From: Ian Brewster
Sent: 15 December 2010 13:22
To: Peter Cleveland
Subject: B/33/10/ Ilex Cottage The Street Burpham BN18 9RJ

the trees of most significance within the grounds of this proposed re-build project are the Beech and Evergreen Oak, located to the front of the property and adjacent to the highway. Barrel Tree Consultants have rightly scored both trees highly within Appendix 3, as category 'A', however, their location isn't ideal as they could restrict vehicular access from the road due to an encroachment into their Root Protection Areas (RPA). The Tree Consultant has addressed this issue by highlighting special precautions within a shaded zone as seen in plan 10116-BT1 and this must be adhered to. The ground is raised near to the main stems of both trees and the level tapers from an approximate height of 0.45m to meet the existing highway surface. There are visible surface roots through the shingle layer of the driveway and any surface reduction for a new surface would affect these and the subsequently the health of the trees. Therefore any special surface will need to be raised to incorporate the evident underlying roots and taper without excavation.

10116-BT1

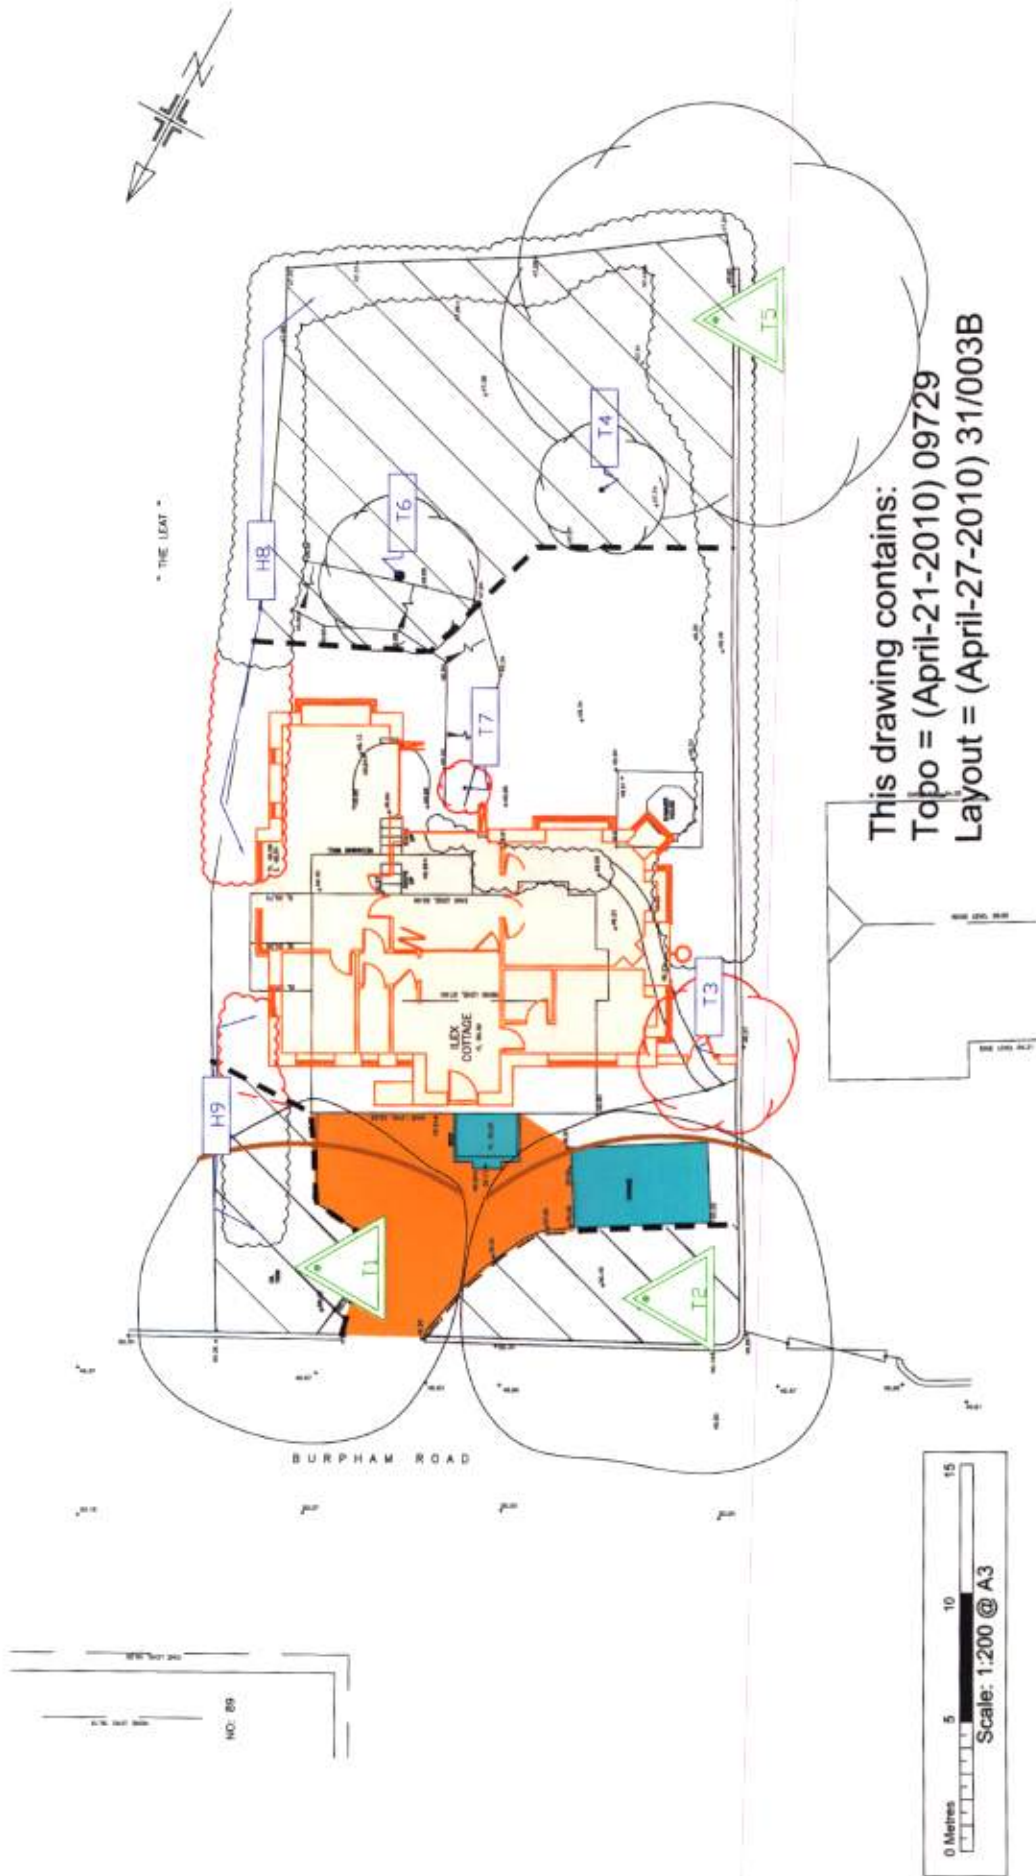
It is recommended that a Council representative is available to inspect the site to ensure that all tree works and protective measures, including fencing and ground protection are satisfactory before the commencement of demolition and construction activities.

The upgrading and installation of new services should be carried out using 'trenchless' technology as recommended in the Consultants report section 4.3.3. and form part of a Planning condition.
